From: Pat Nicholson
Sent: Thursday, October 31, 2019 4:12 PM
To: RichElliott; Chelsea Benner
Cc: Joe Seemiller; John Sinclair
Subject: RE: [Ext] Notice of Application and SEPA SV-19-00001

Subject: [Ext] Notice of Application and SEPA SV-19-00001

THAYER PROPERTY DEVELOPMENT
 FOR SINGLE FAMILY RESIDENCE
 SECTION AT MIDDLE OF BRIDGE
 DRAWING 5

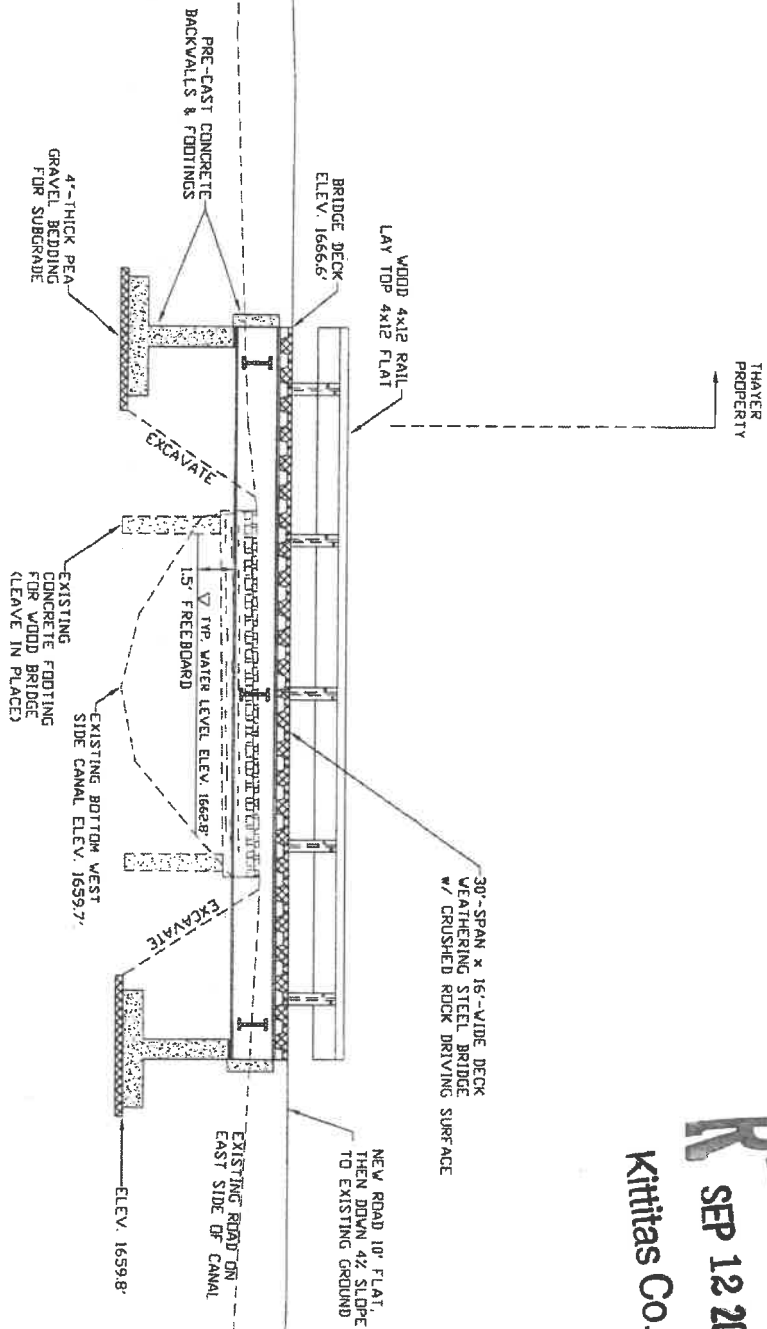
The new bridge will need to be posted for loads 75,000lbs + and meet minimum width requirements.
